Your Ref: 2016/62/90494/W
Our Ref: S003561

2nd March 2017

adj Old Bank Mill, Howgate Road, Slaithwaite, Huddersfield - Amended Plans

PROPOSED RESIDENTIAL DEVELOPMENT AT OLD BANK, SLAITHWAITE			
CLIENT S.B. HOMES LTD			
WILLIAM BEST RISA THE CHAPEL HOUSE 22, FOLE GATE SCAMMONDEN WEST YORKSHIRE HD3 3PW 01484 845896			
DRAWING: PROPOSED SITE PLAN			
SCALE:	B4	DATE	
1:200	WB	14/01/2016	
2015/319	100

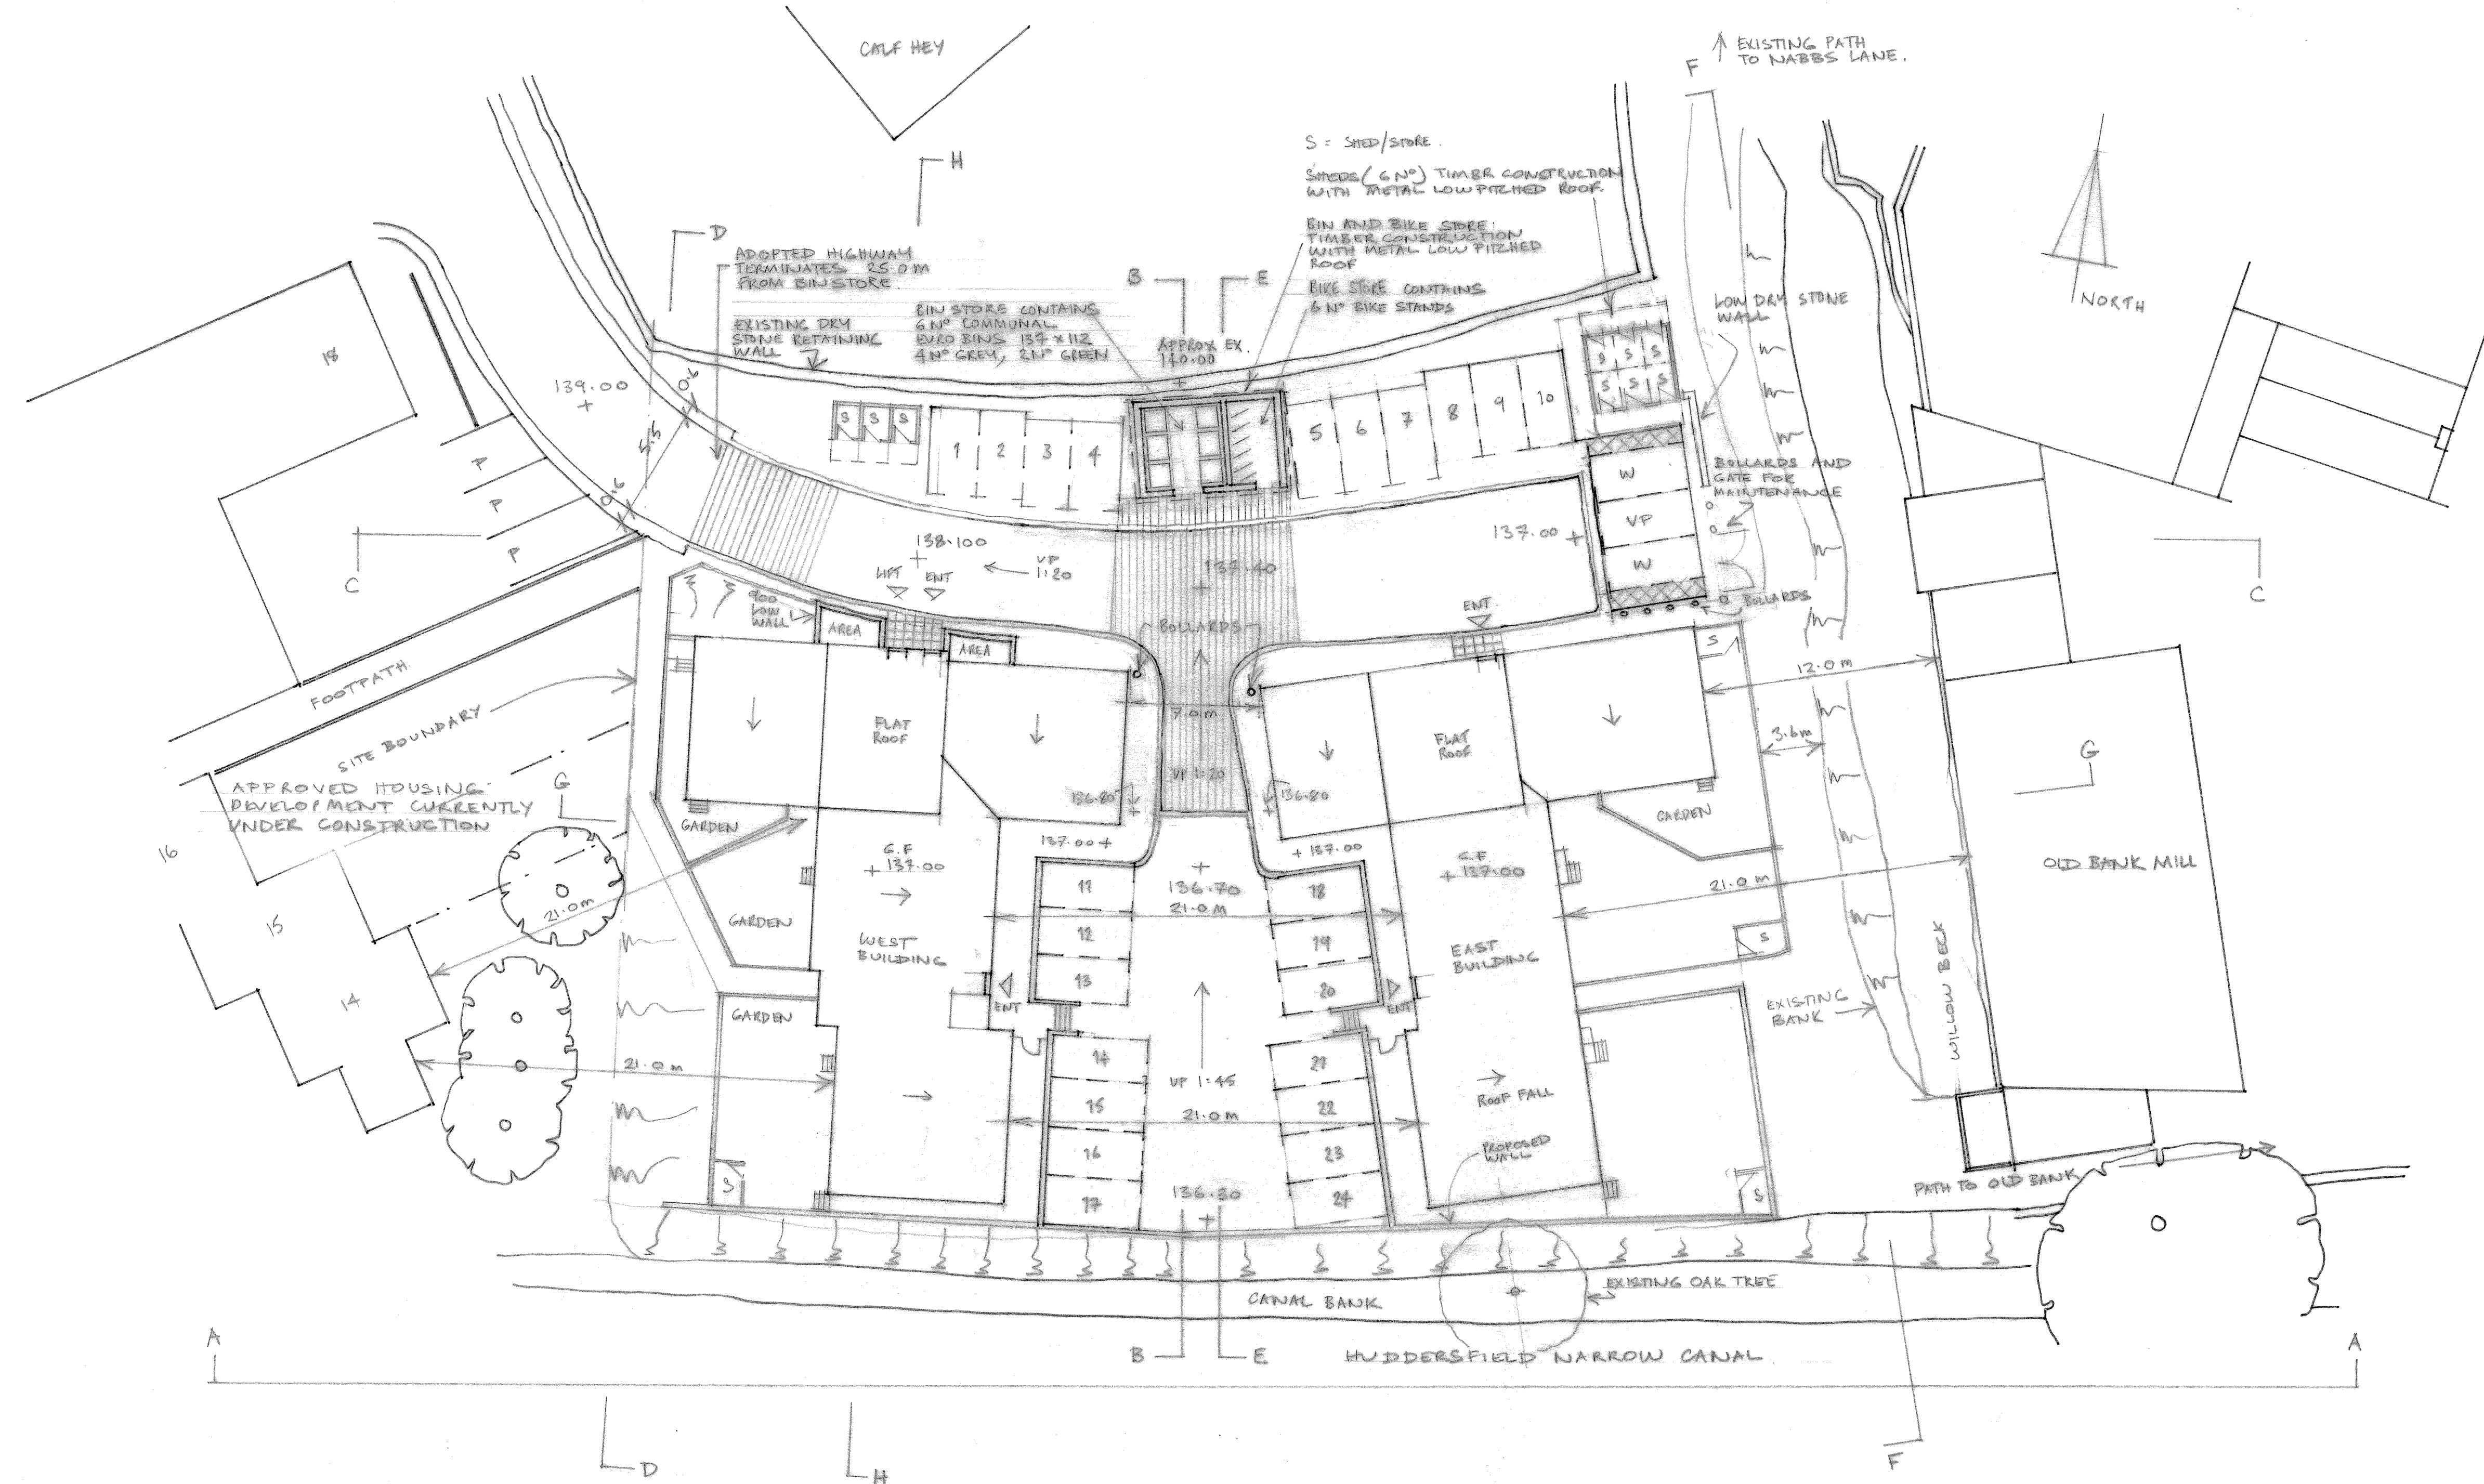
SITE LAYOUT - Yorkshire Water has no objection in principle to:

i) The proposed site layout (in relation to the public sewer and 3 metres stand-off distance)

as submitted on drawing 2015/319/100 (revision B) dated 22/12/2016 that has been prepared by William Best RIBA.

DRAINAGE - The submitted drawing does not show any foul water or surface water drainage proposals.
